**RE: EXHIBITION OF STATE SIGNIFICANT DEVELOPMENT (SSD 8926) FOR 2 PERCY STREET, AUBURN**

Thank you for providing the opportunity to comment on the exhibition of the proposed State Significant Development - SSD 8926 (new K-12 school) at 2 Percy Street, Auburn.

**SSD Issues**

01 PLAN
Level 1 (Ground)
Scale 1:500

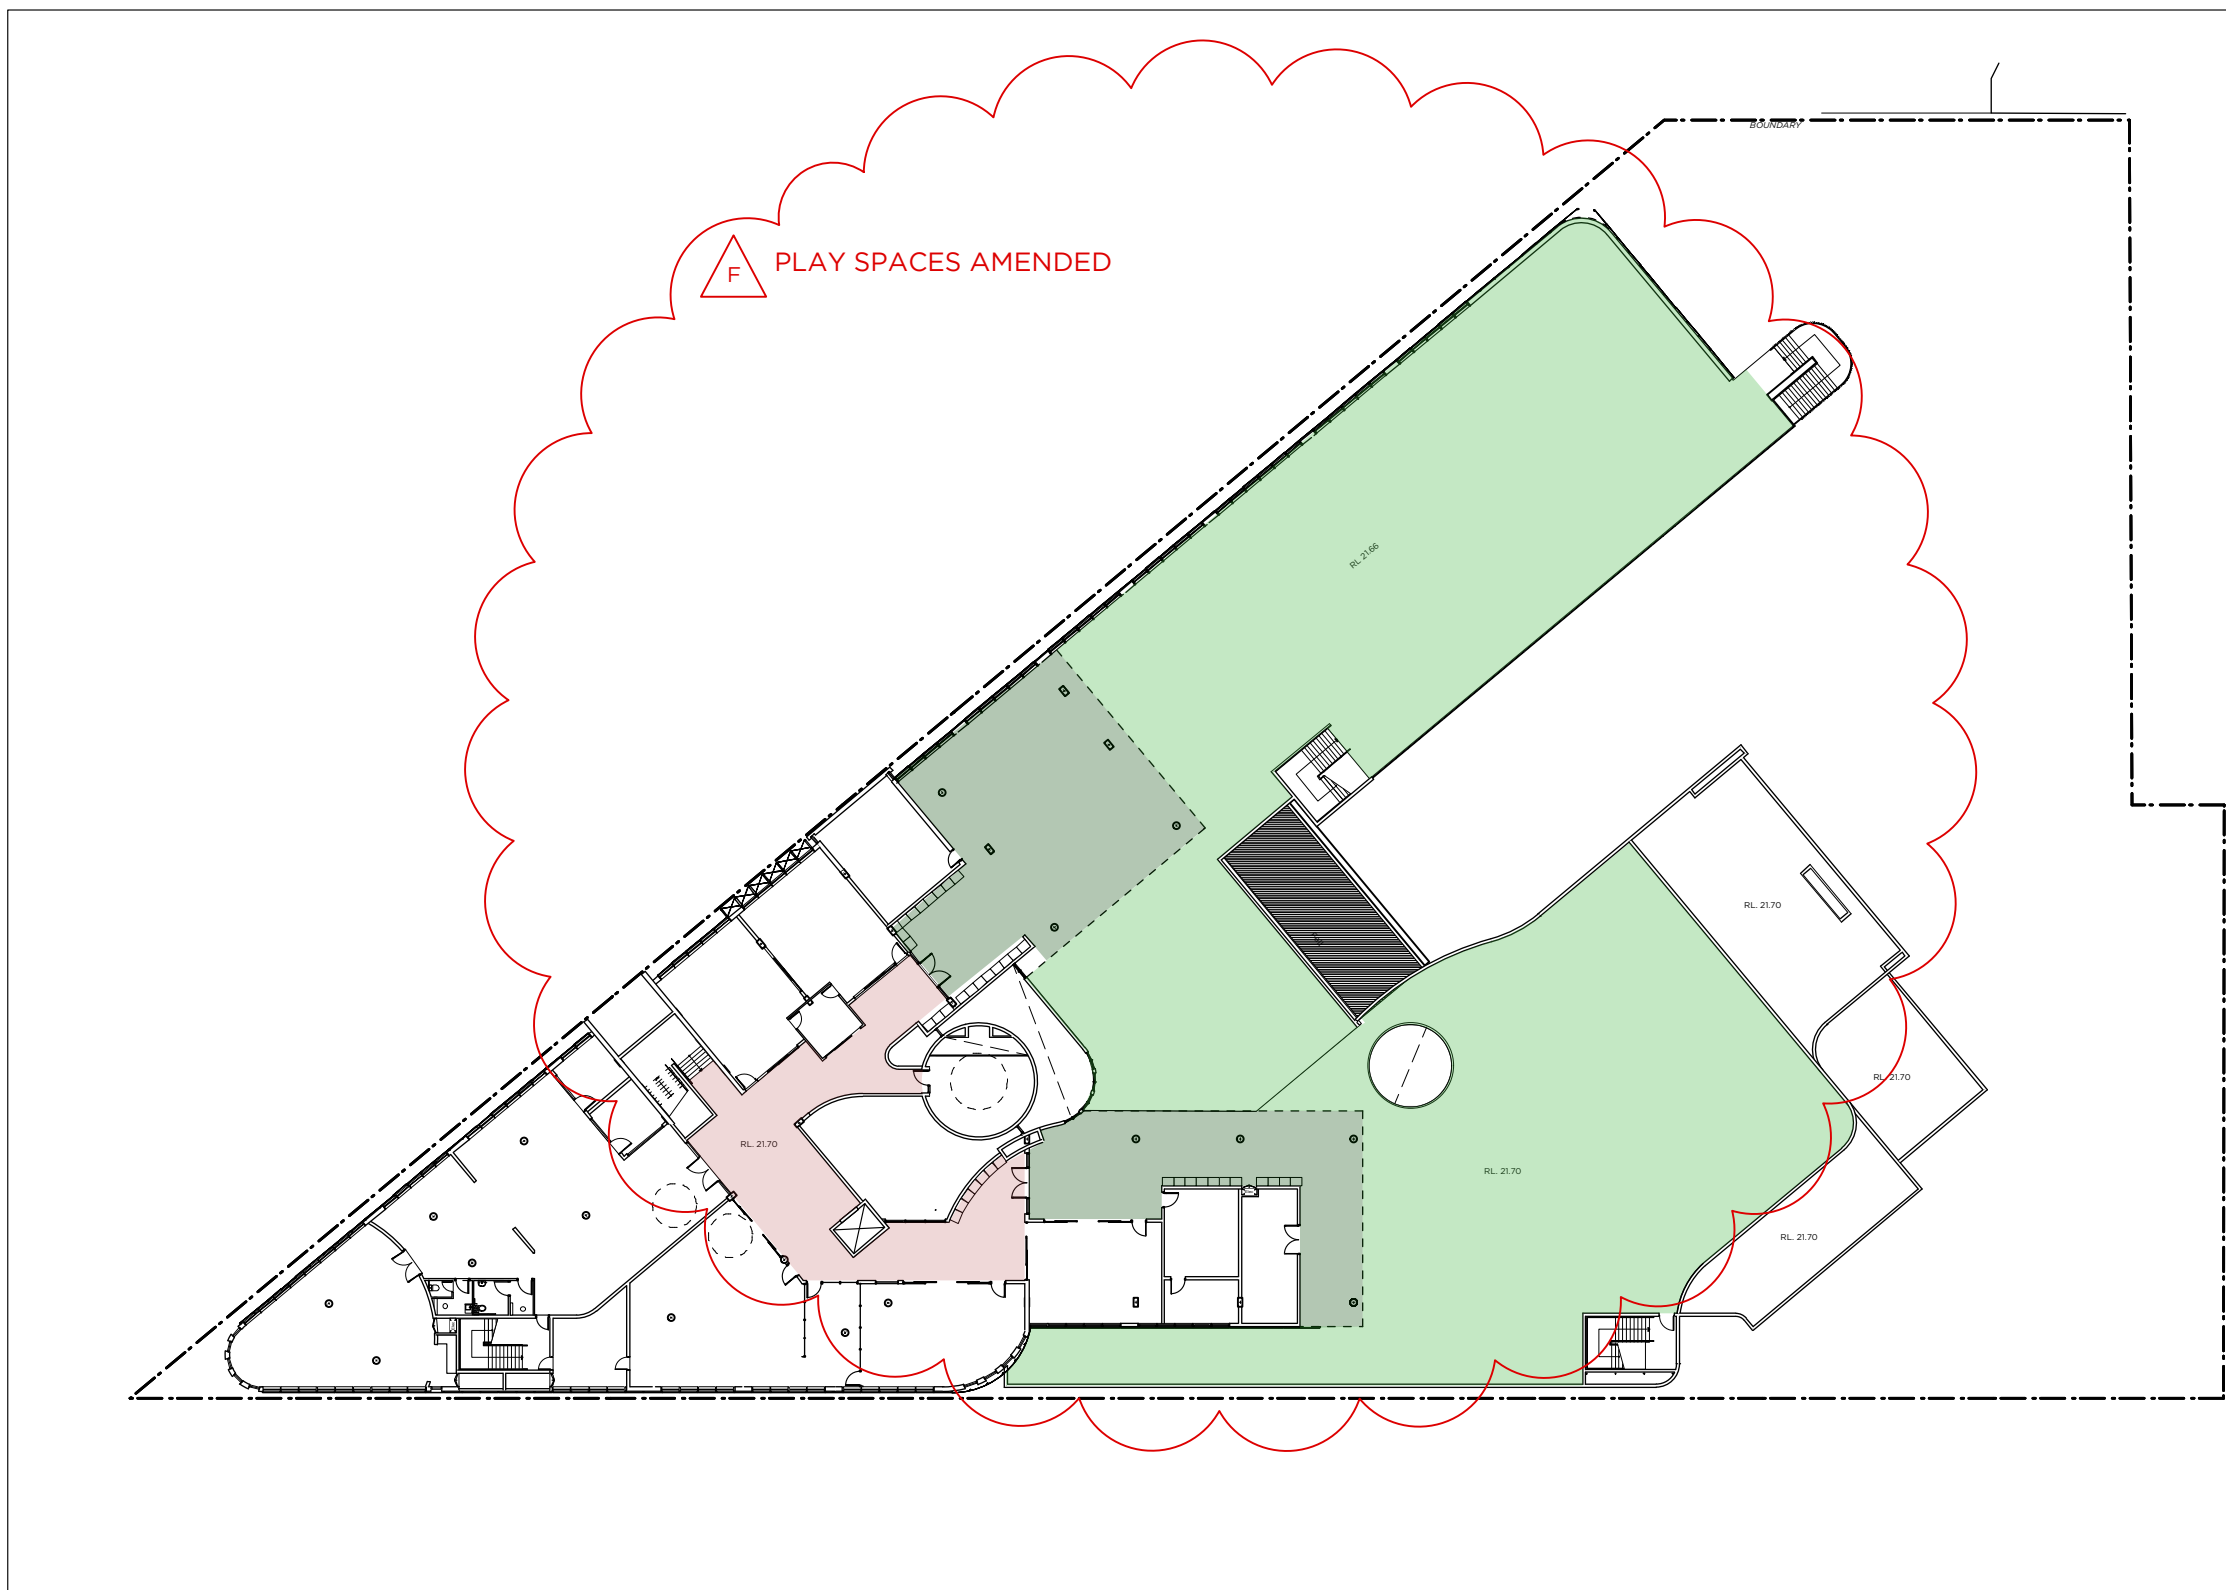
#### **7. Play/open space calculations (Ref drawing DA611)**

This drawing does not indicate a percentage or quantify how much active/passive play and open space is proposed for each level of the proposed development. Further, the plans show 'under cover space' and it is not clear if this type of space can be taken as play and/or open space. Clarification of this is recommended.
